**Fenwick Solar Farm
EN010143**

**Applicant's Response to Examining Authority's First Written
Questions (ExQ1)**

Document Reference: EN010152/APP/8.21

May 2025
Revision Number: 00

Purpose Of Issue
DCO APPLICATION
Project Number
 60698207
Sheet Title
 STREETS, RIGHTS OF WAY AND ACCESS PLANS SHEET 4 OF 11
Reference Number
 EN010152/APP/2.4
Legislation Reference
 APFP 2009 Regulation 5(2)(k)
Sheet Number
 60698207-ACM-HGN-00-DR-CE-2004
Scale: As shown @ A1 **Rev:** p03

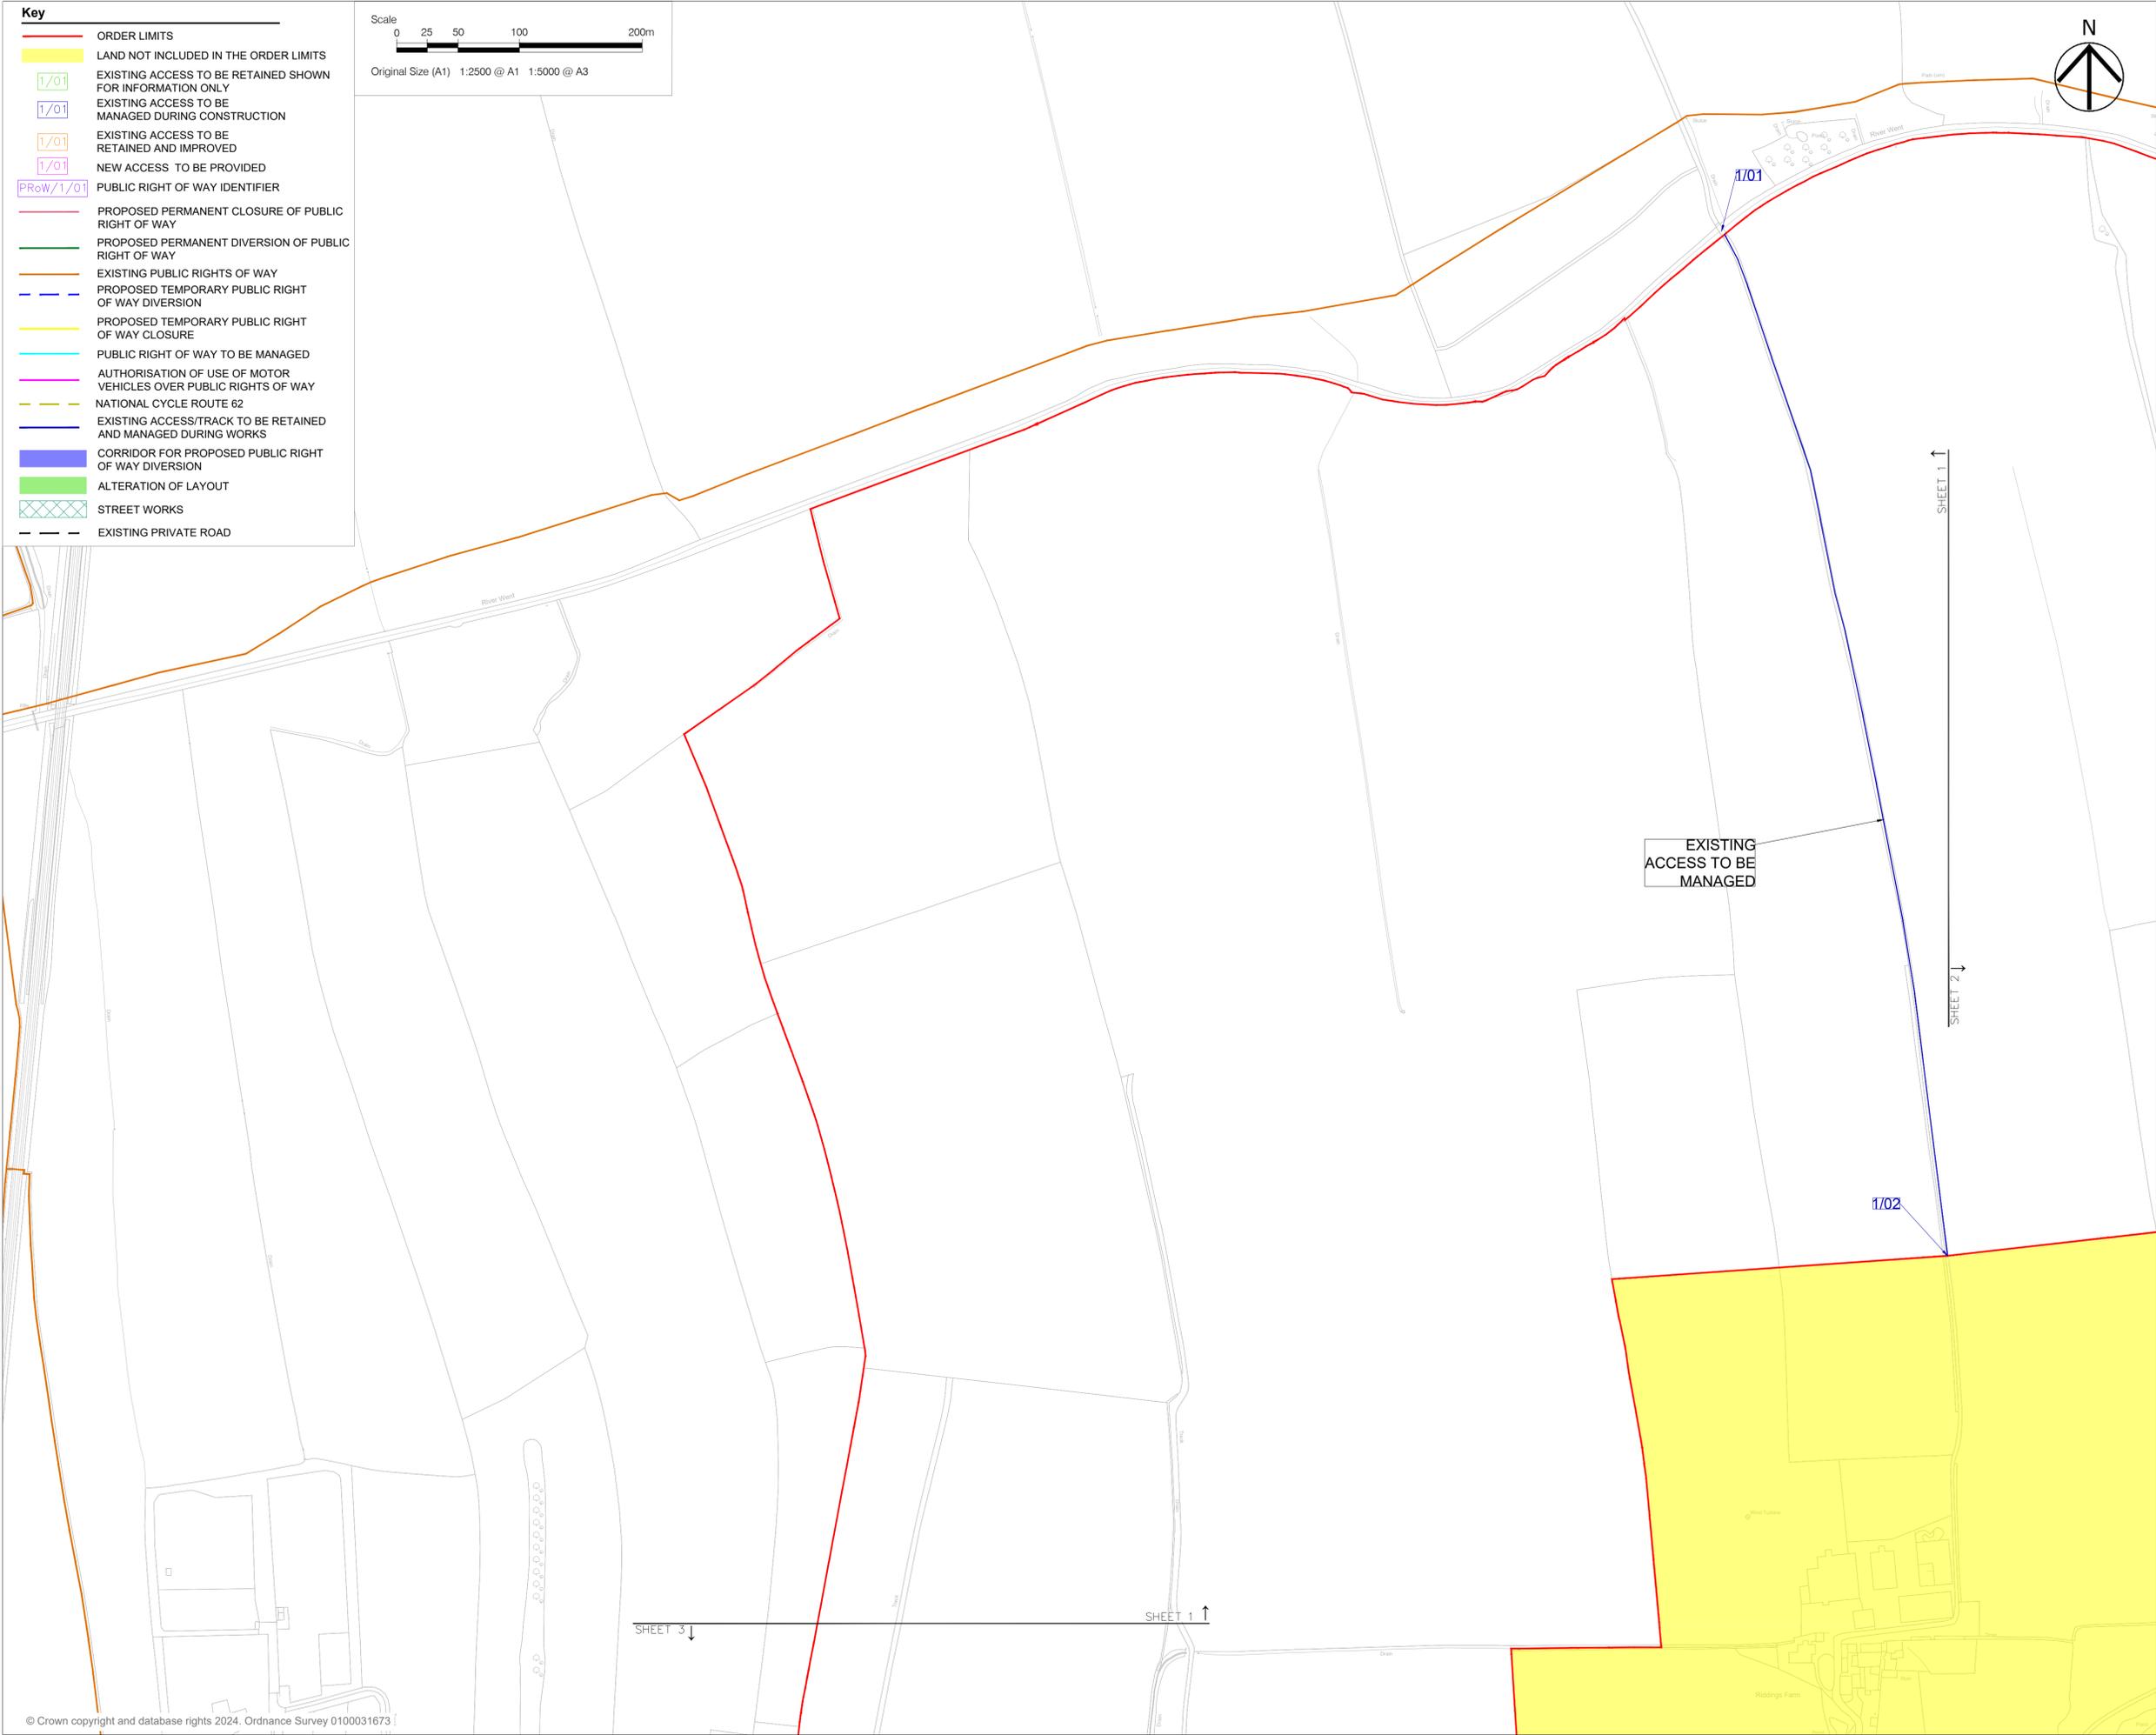
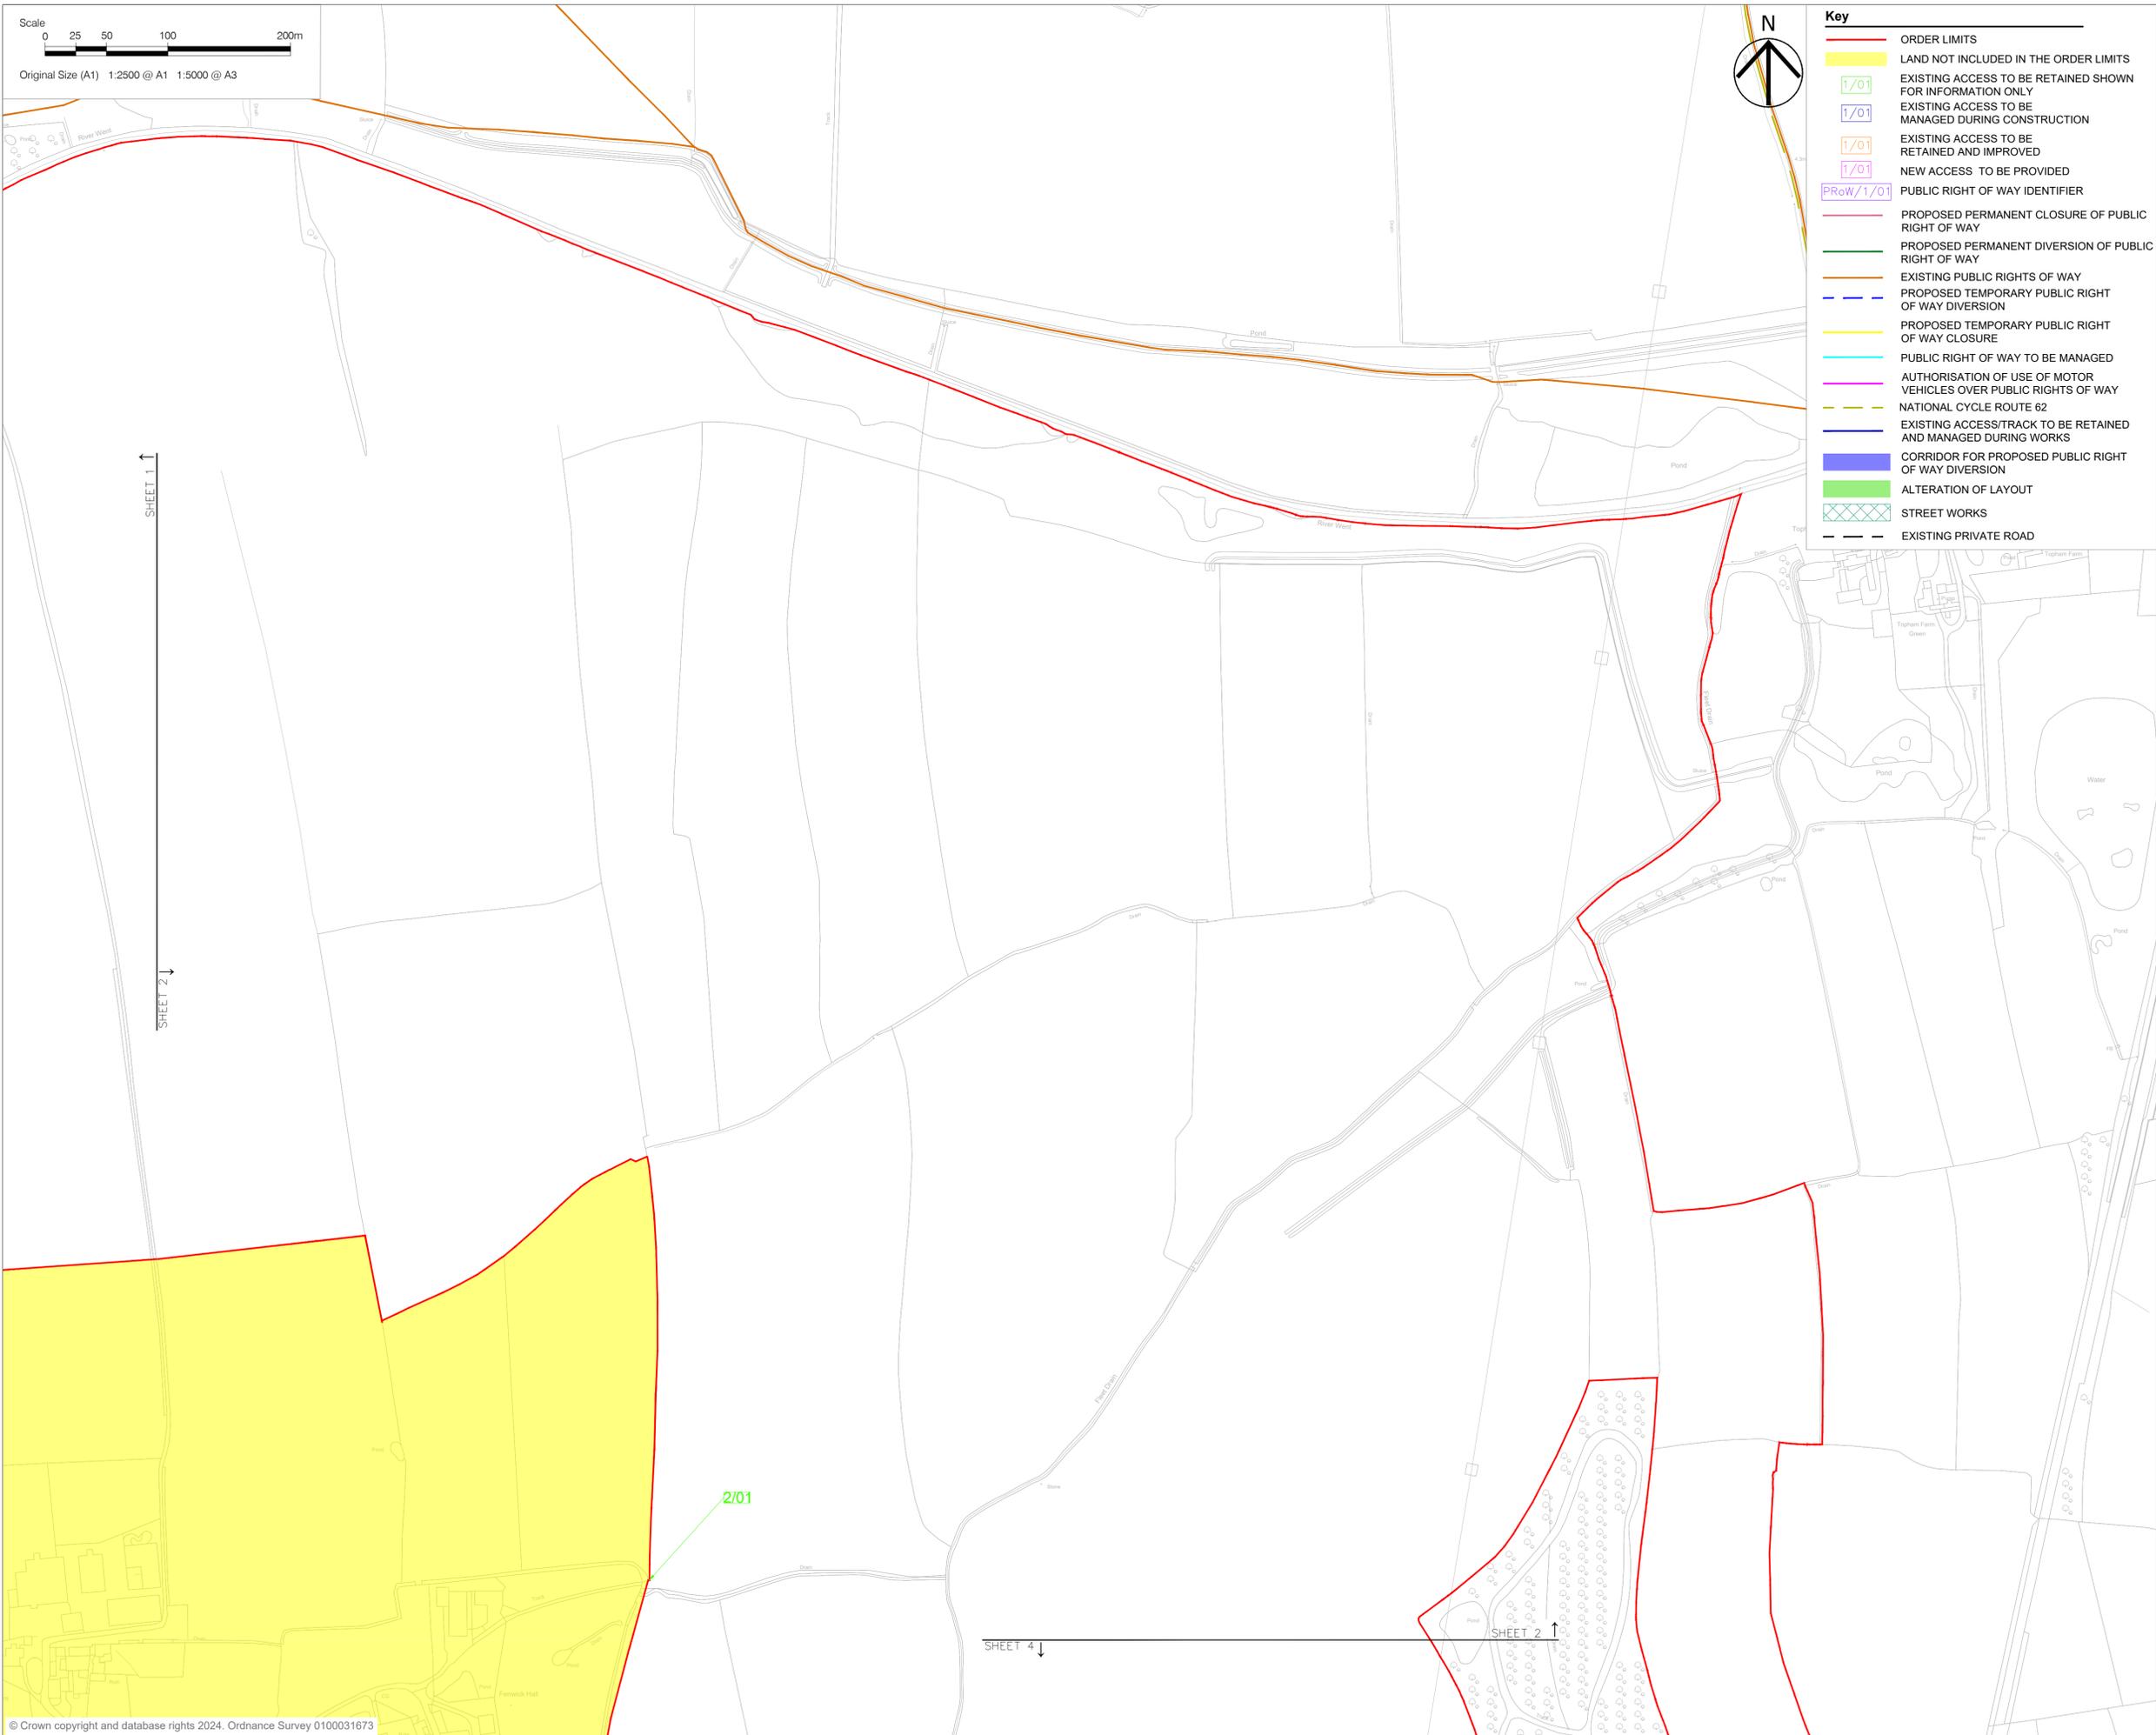
1.1.19	Applicant	<p>Schedule 4 (Streets subject to street works)</p> <p>The ExA notes the use of the words 'within proximity of' in this schedule are insufficiently precise. Please amend to a more precise form of words (eg. 'between points [x] and [y]') or provide a further justification for their use.</p>	<p>The Applicant considers the wording is sufficiently precise when reviewing the wording as against the Streets, Rights of Way and Access Plan (Revision 03) [EN010152/APP/2.3], as while the access points are used as a locational tool to help identify the area of streetworks within each sheet, the powers themselves are constrained instead to “the length shown in green patterned hatching”. The Applicant considers that to further define these</p>

ExQ1	Respondent	Question	Applicant's Response
			<p>extents using additional markers confirming the various edges of these streetworks would make this Plan overly cluttered and less applicable for the undertaker and local streets authorities.</p> <p>It is further noted that this approach to identifying streetworks (ie to rely on the areas as shaded in highlight or hatching) has been adopted and considered sufficiently precise on other recently made solar DCOs, including the Gate Burton Energy Park Order 2024, the Mallard Pass Solar Farm Order 2024 and the East Yorkshire Solar Farm Order 2025.</p>
